From: Sue Howell <Sue.Howell@arun.gov.uk>
Sent: 29 October 2019 15:14
To: Planning.Responses <Planning.Responses@arun.gov.uk>
Cc: Andrew Wood <Andrew.Wood@arun.gov.uk>
Subject: RE: Planning Consultation on: A/45/19/PL

Comment from Greenspace

Registered: 9th April
 2019
Site Address: Bmw House, Chandlers Garage Ltd Water Lane
 Angmering BN16 4EH
Grid Reference: 506925 104447

Description of Works: Demolition of existing buildings (car show room, workshops and Phares Courtledge) and erection of 19 dwellings, a convenience store, a community building, public toilets and associated car parking and landscaping - This application affects the character and appearance of the Angmering Conservation Area.

Fig 4. Site Layout

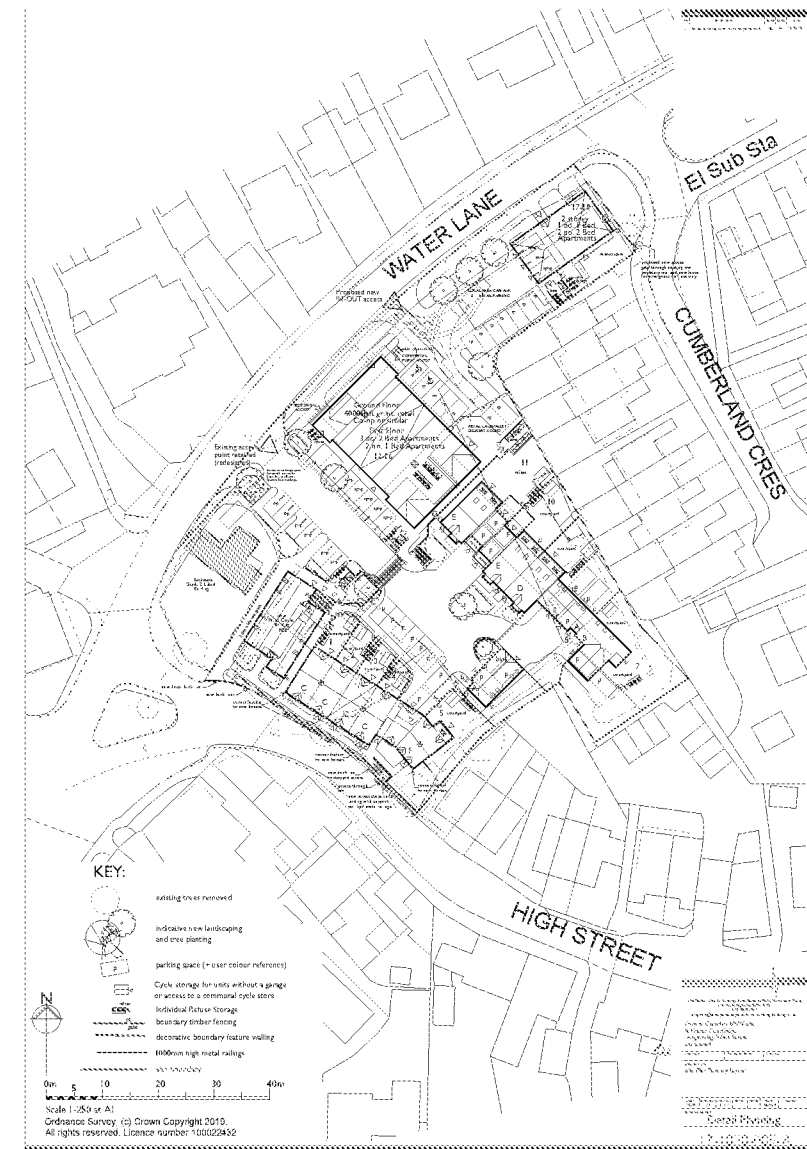
Indicative landscaping has been shown, where further detail will be required forming a scheme that will maximise the biodiversity of the site with the inclusion of mixed ornamental and native species for the creation of a variety of habitats. The landscape proposals will need to be shown in plan form detailing quantities, species choice, planting densities and size at time of planting.

Tree Constraints Plan
Former Chandlers BMW, Water Lane, Angmering

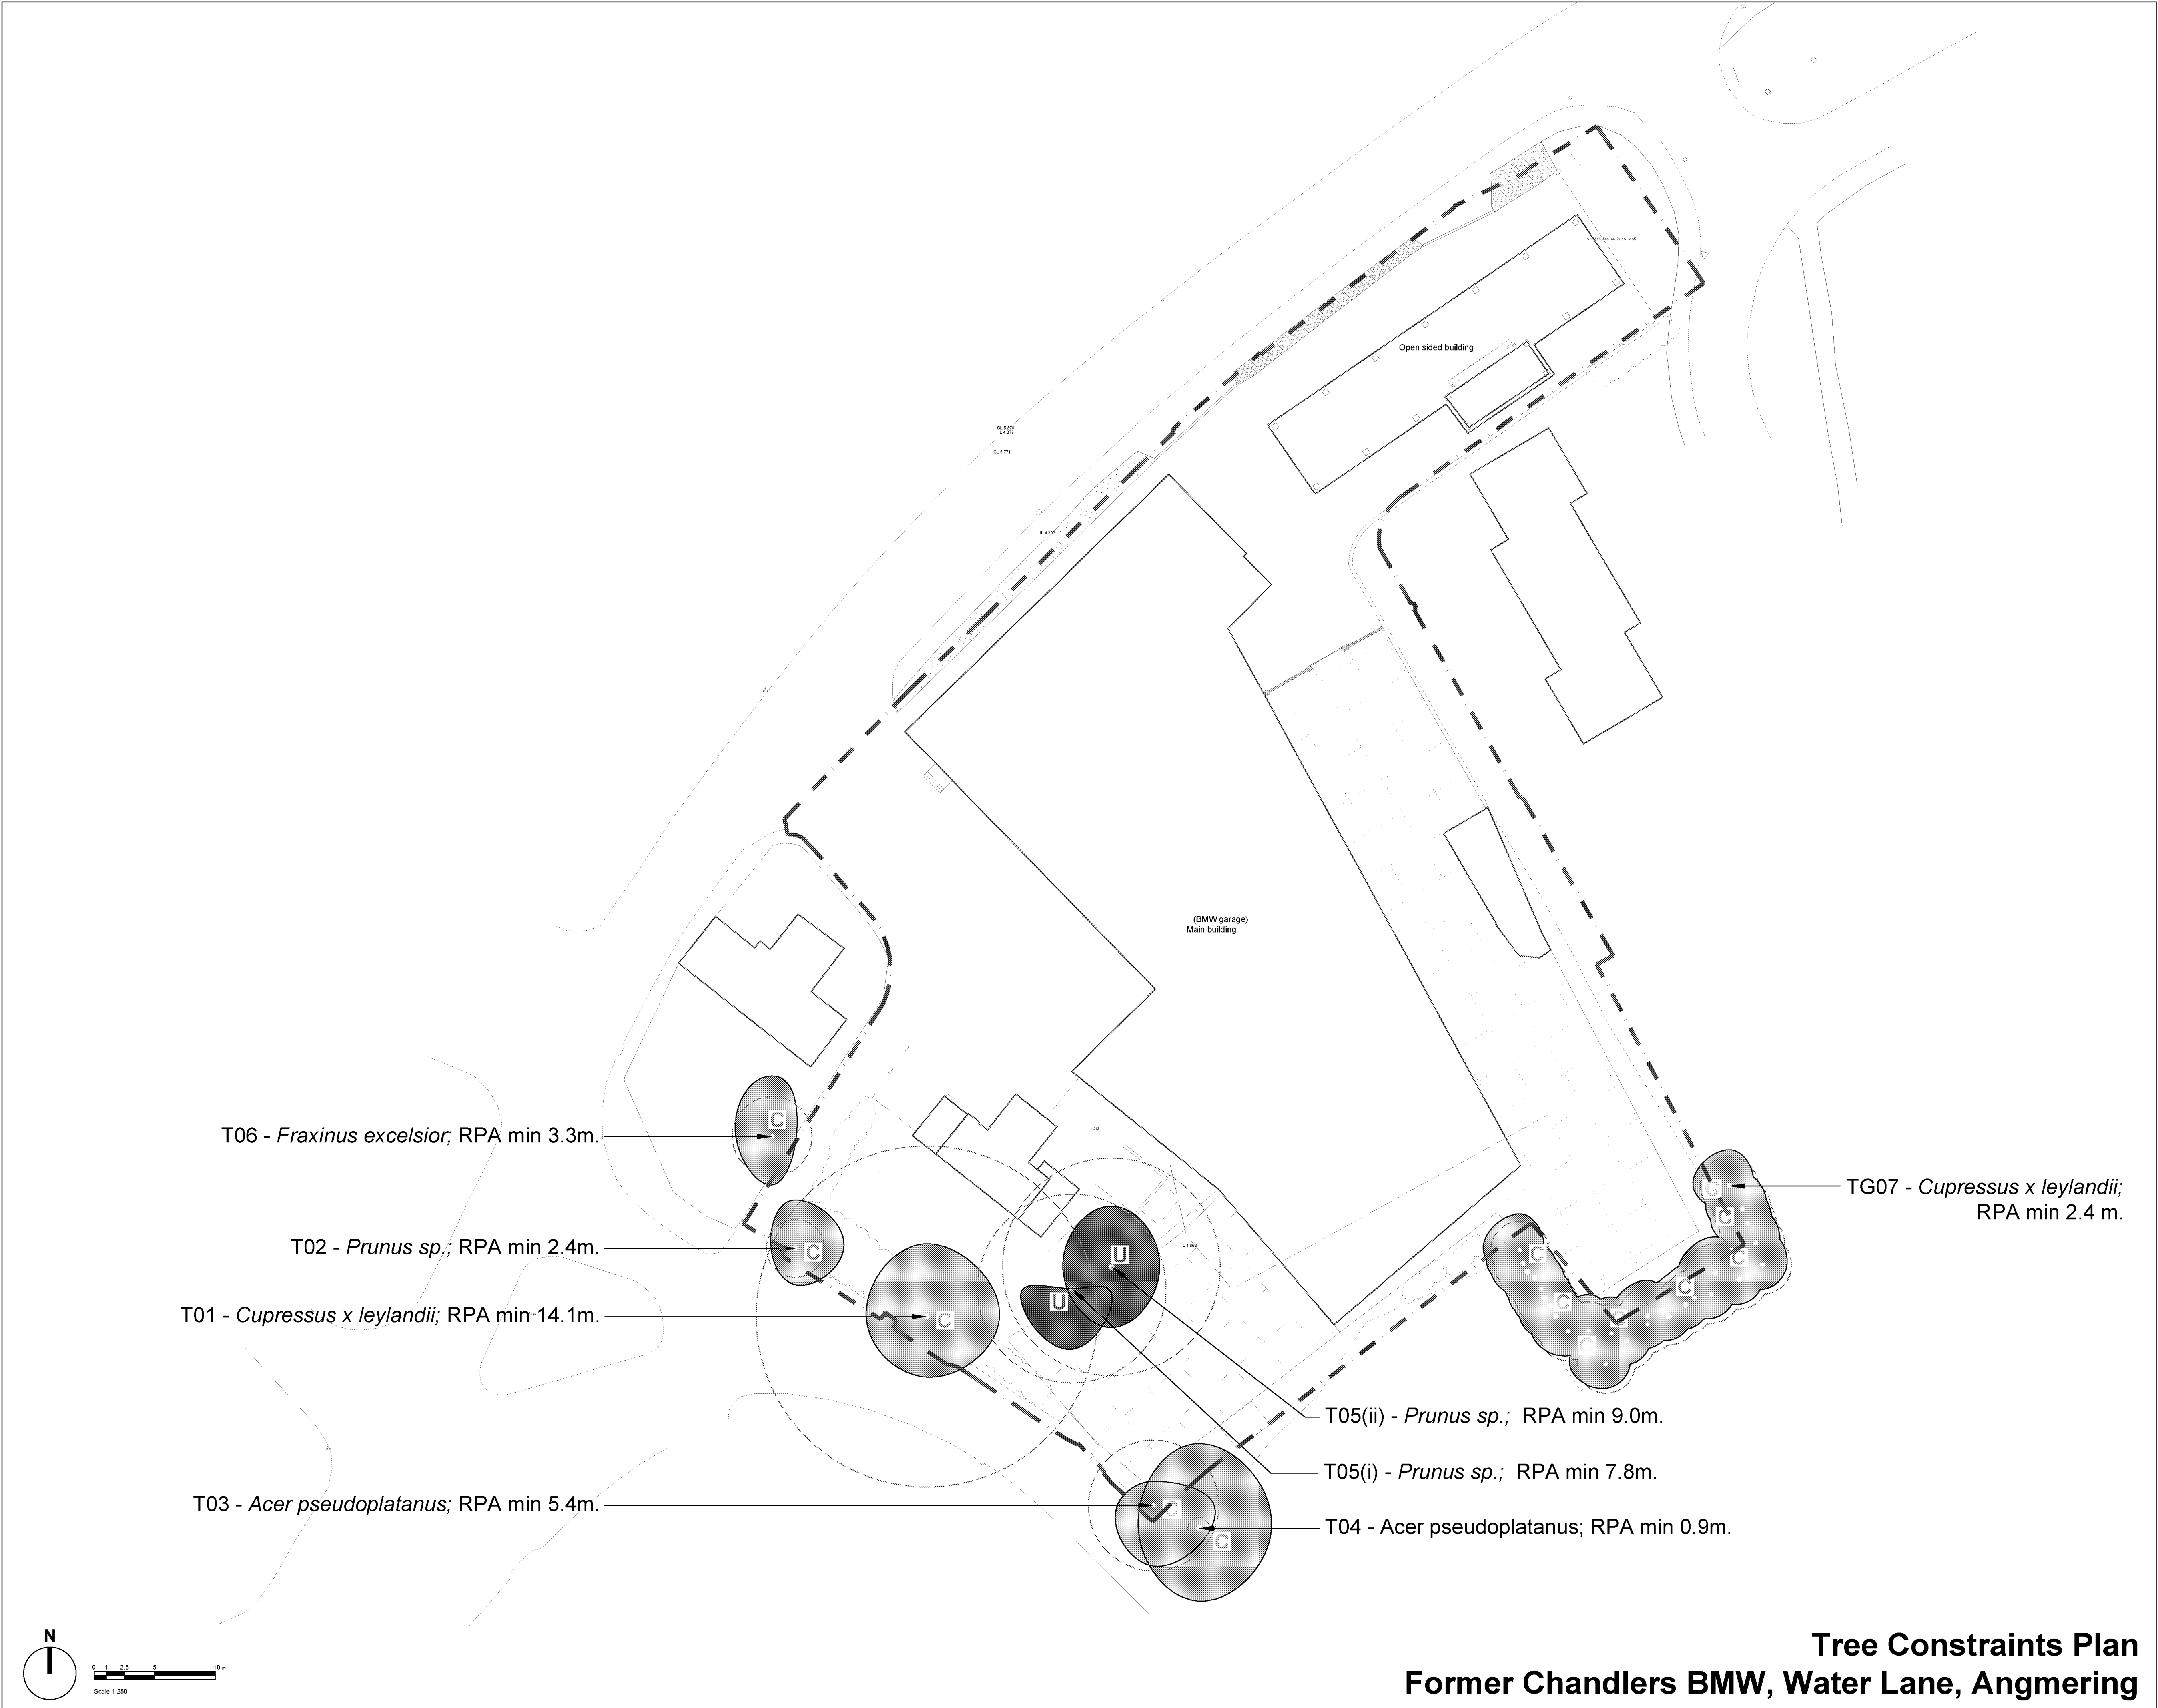
Adjacent offsite trees would need to be considered regarding their protection from the proposed works and appropriate tree and root protection allowed.
